Your Ref: OWPC5845
Our Ref: R/97/15/HH 16-04-2015
Please ask for:
Mr D Easton

Single storey side extension to create kitchen/family room & additional bedroom. Porch extension to front of property
14 Hawke Close Rustington

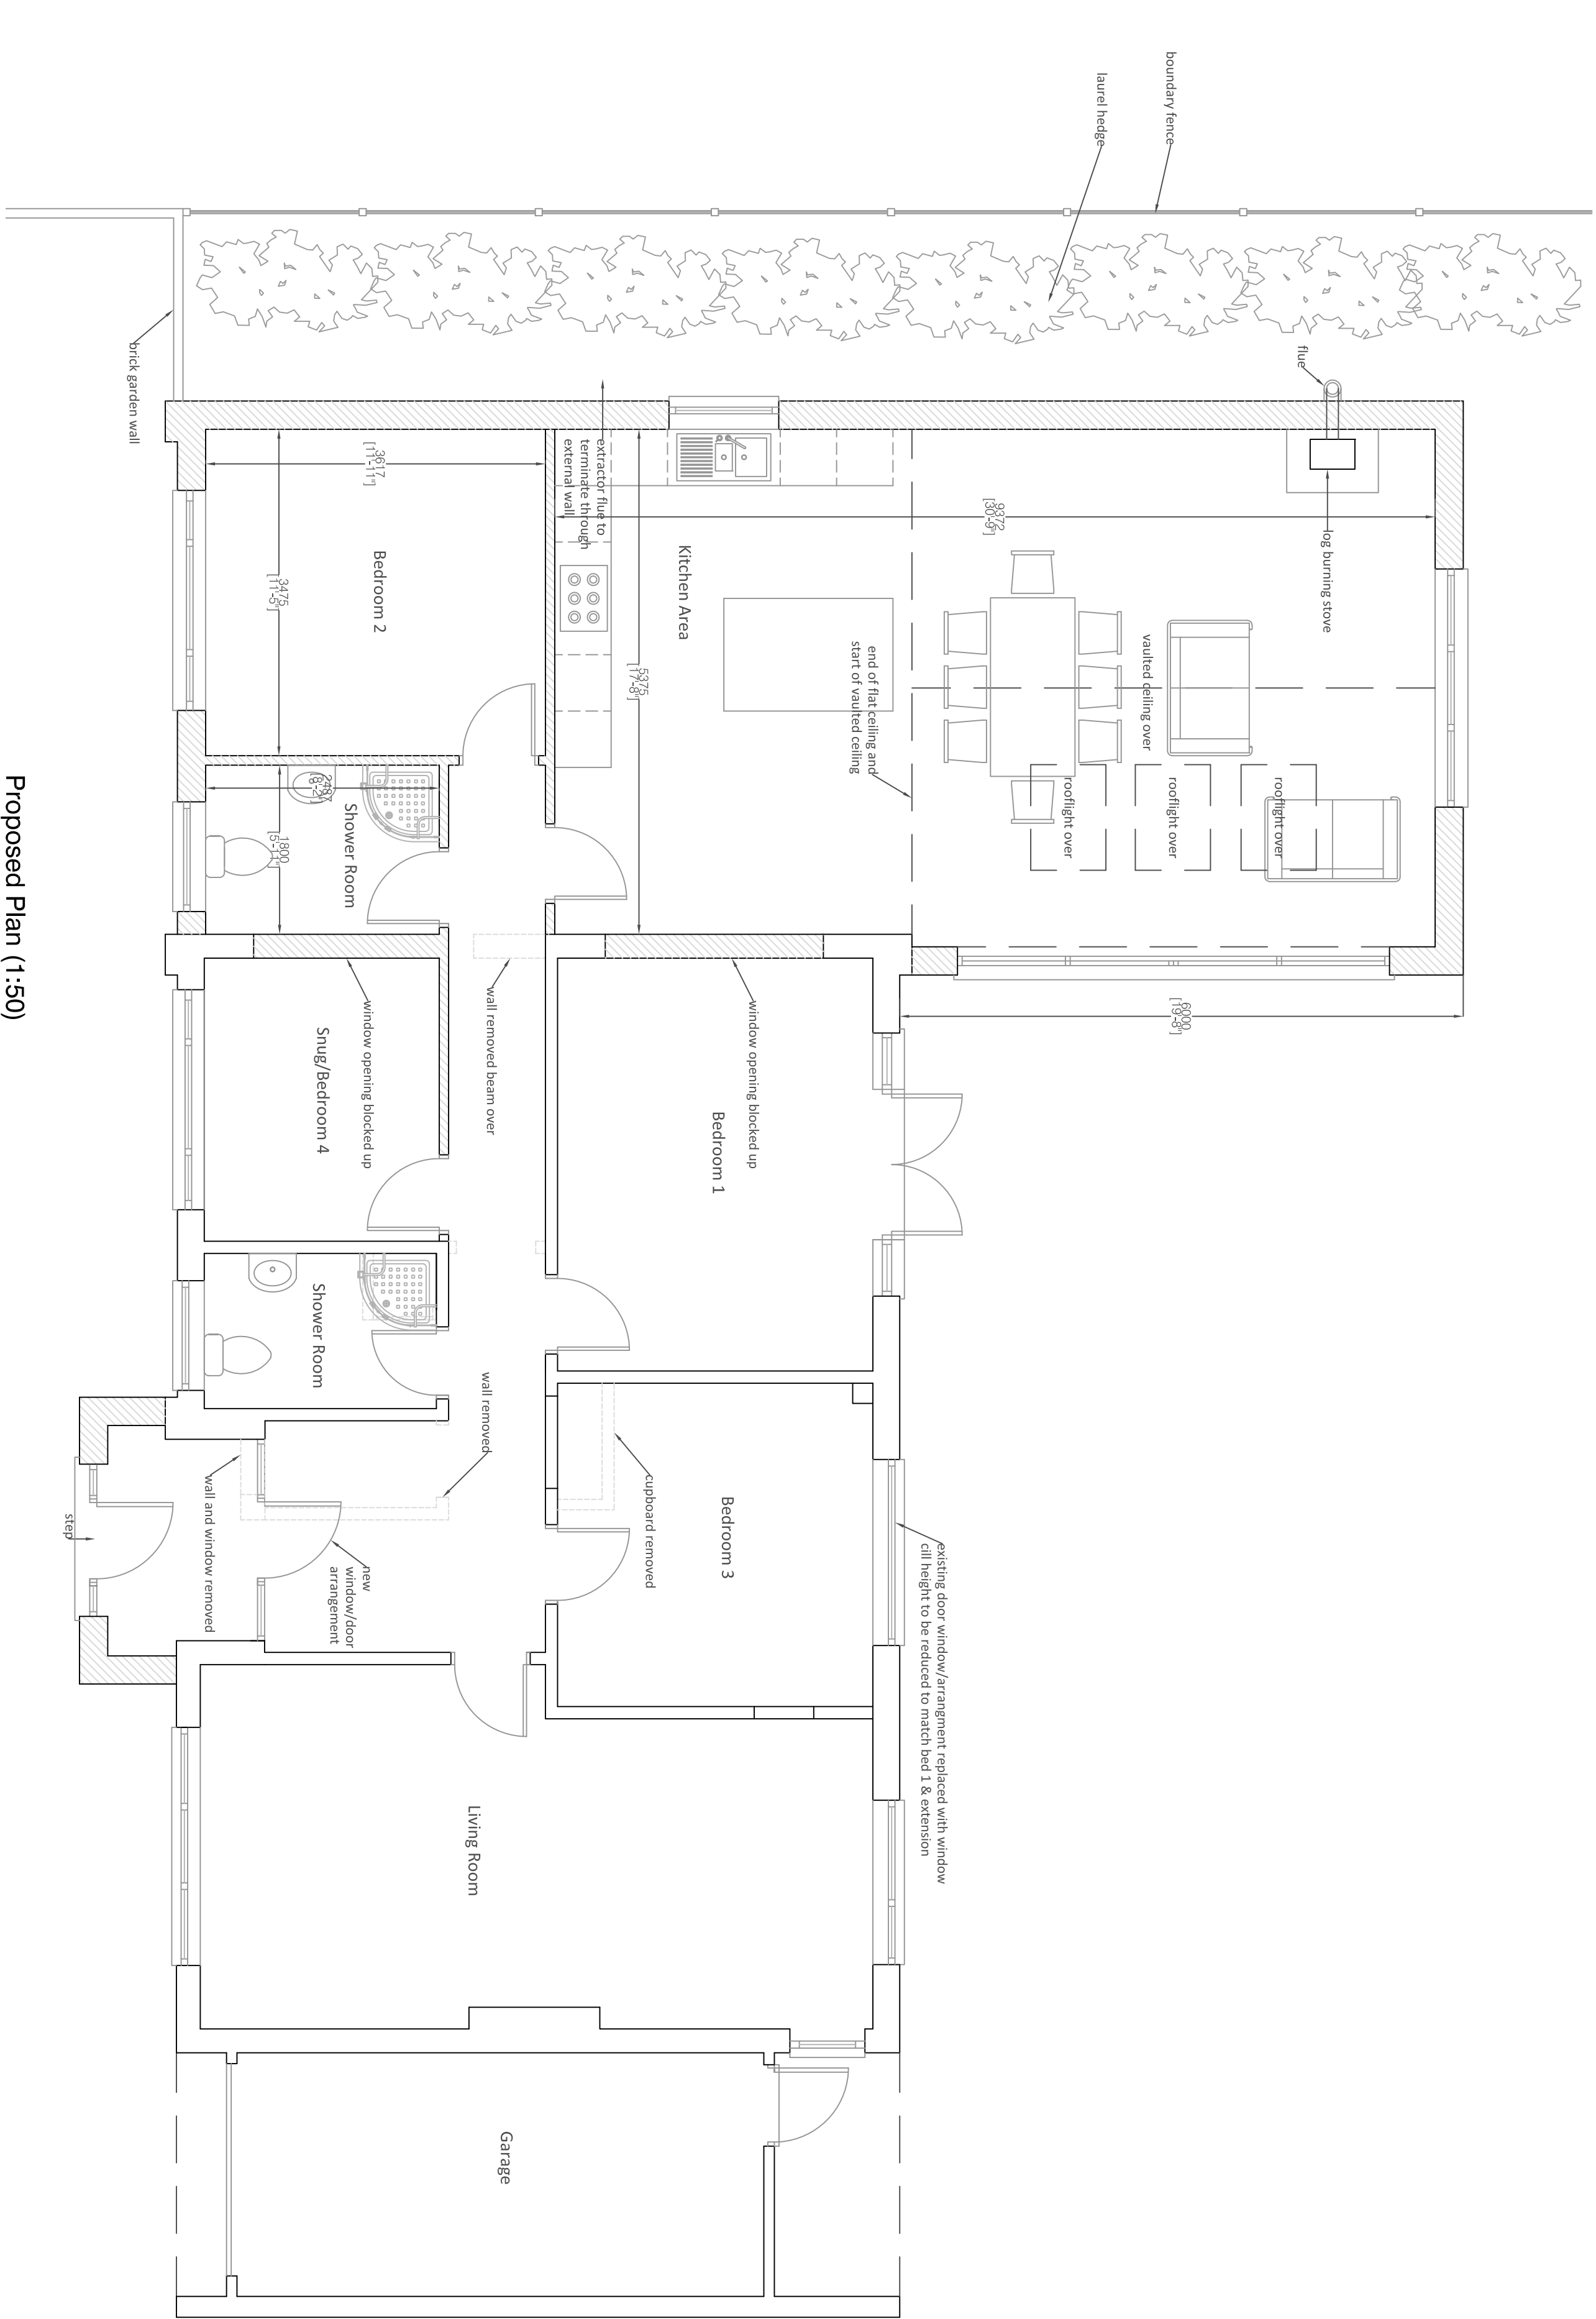
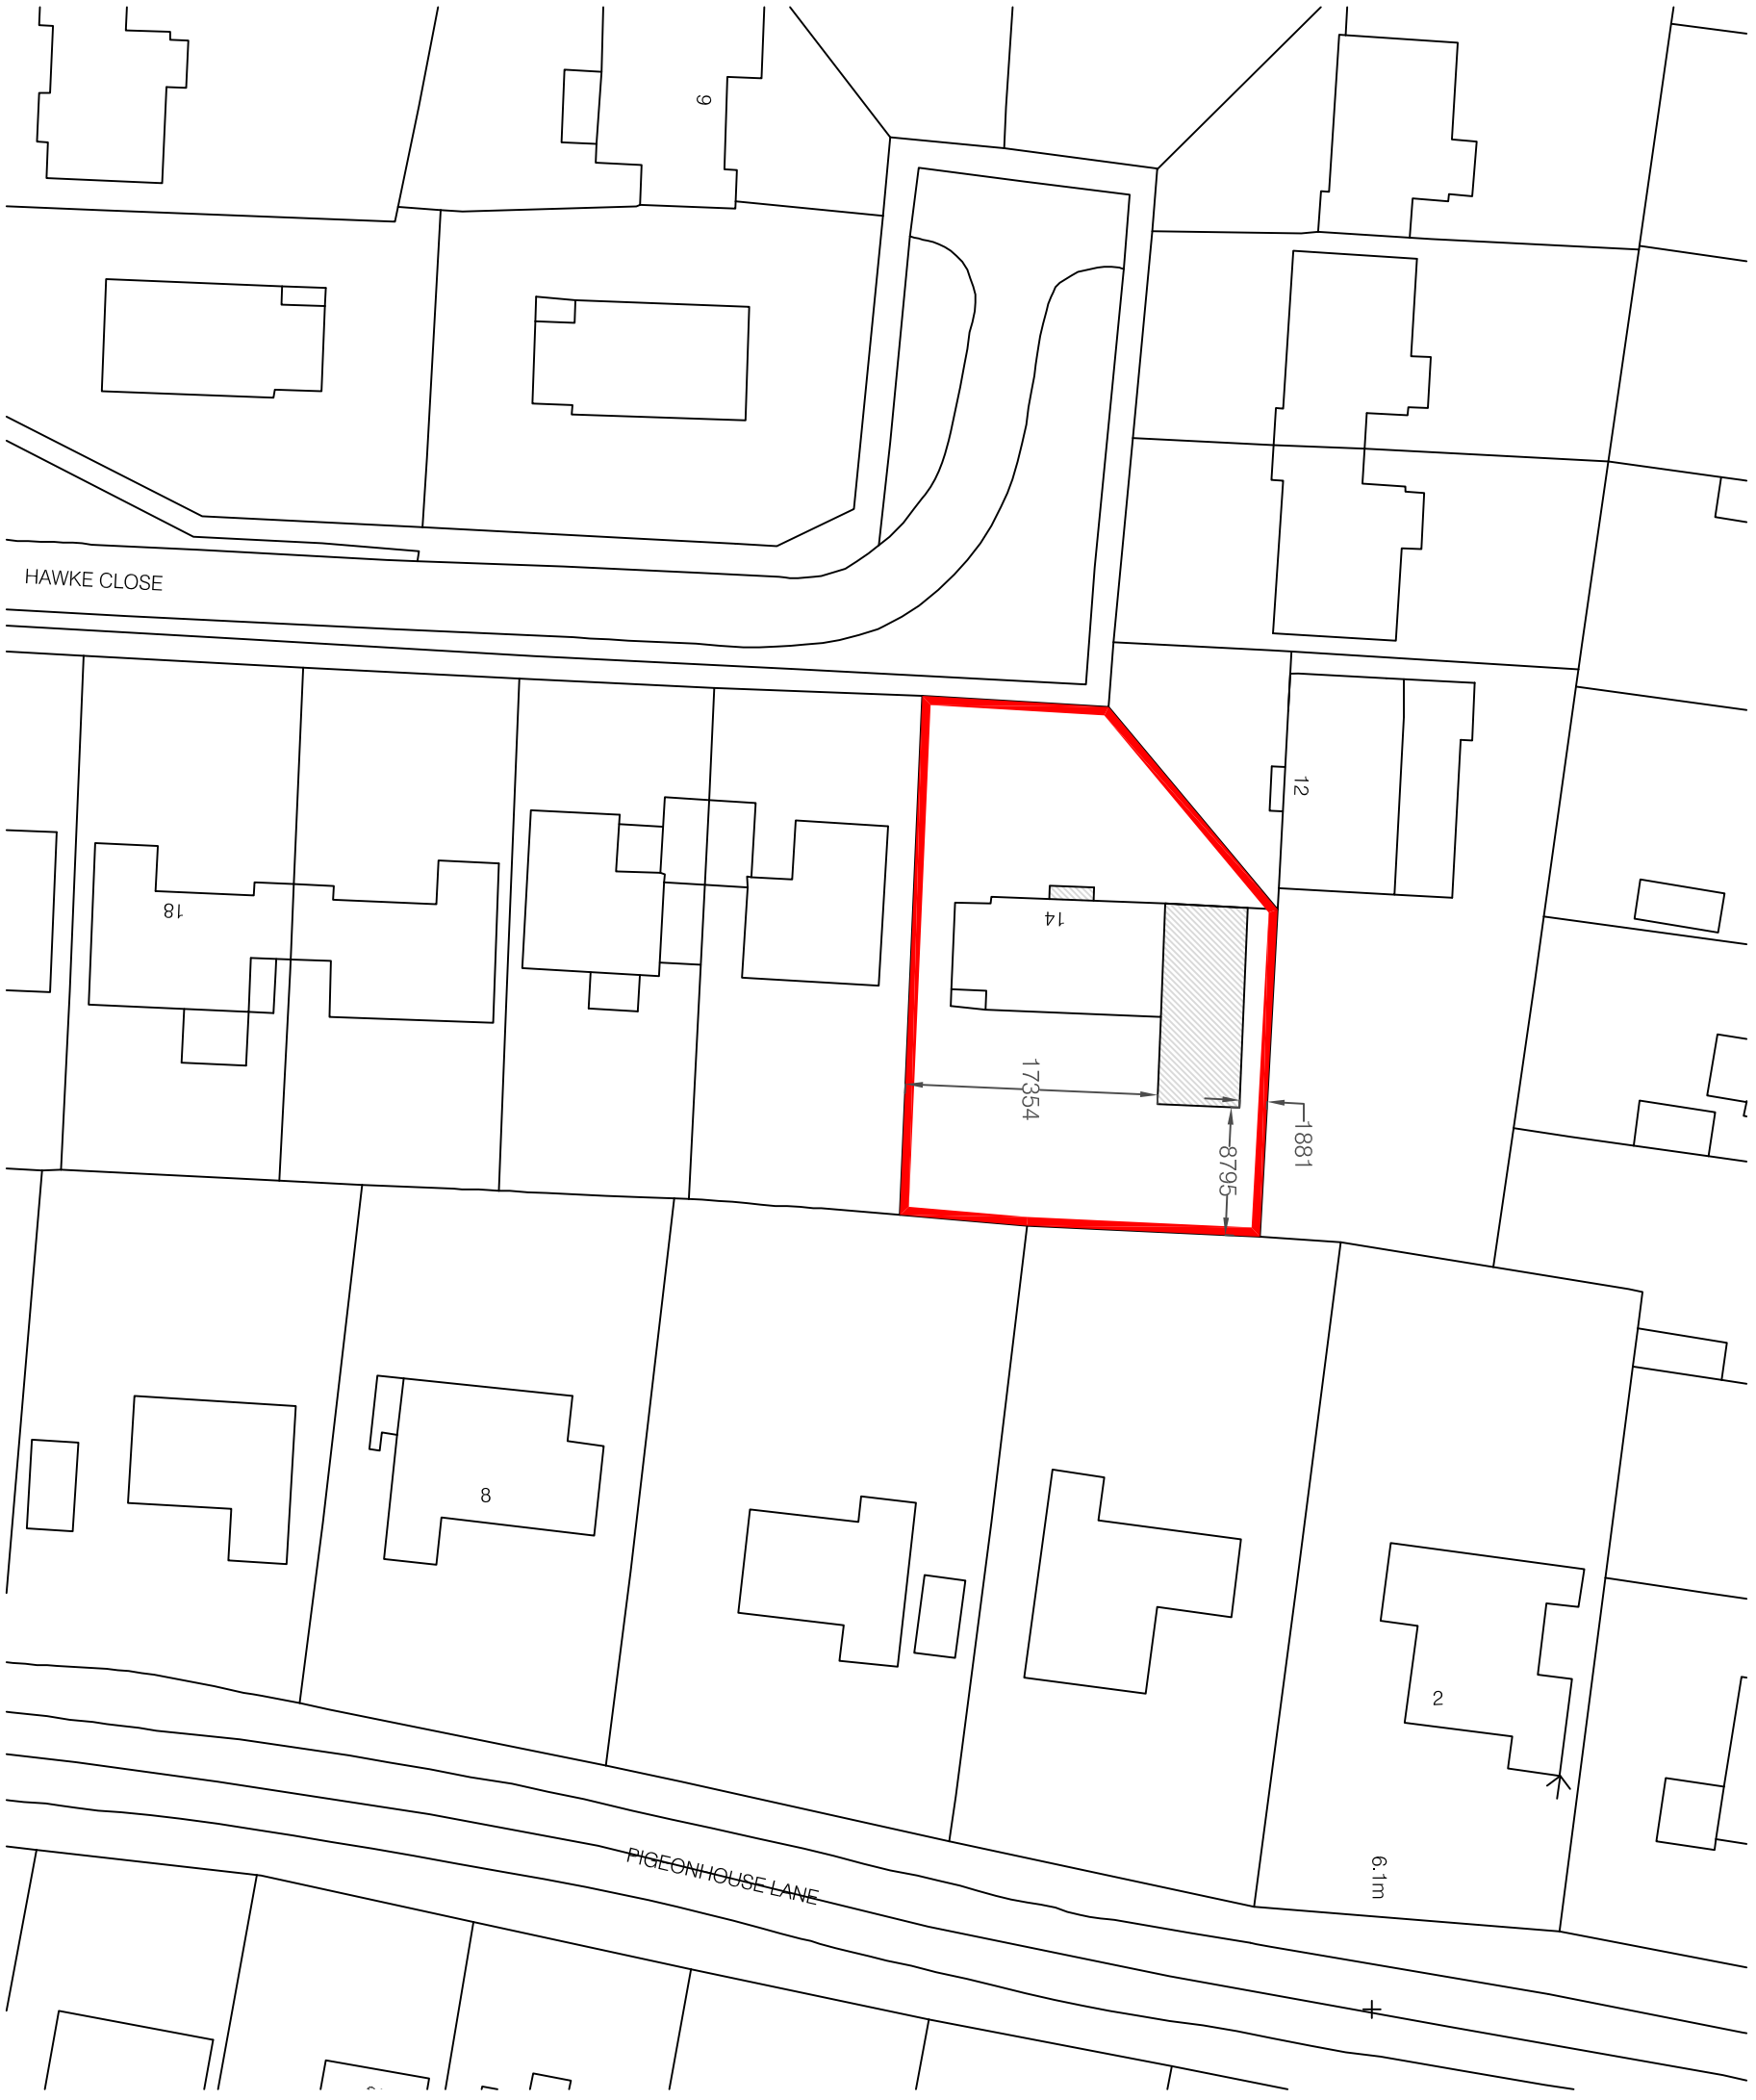
We note that the proposed extension is approx five metres closer to our property and at its closest point to us includes a wood burning stove. As we are downwind of the south west prevailing wind, we object to the noxious fumes exiting this flue we will experience and potentially polluting our home and garden.
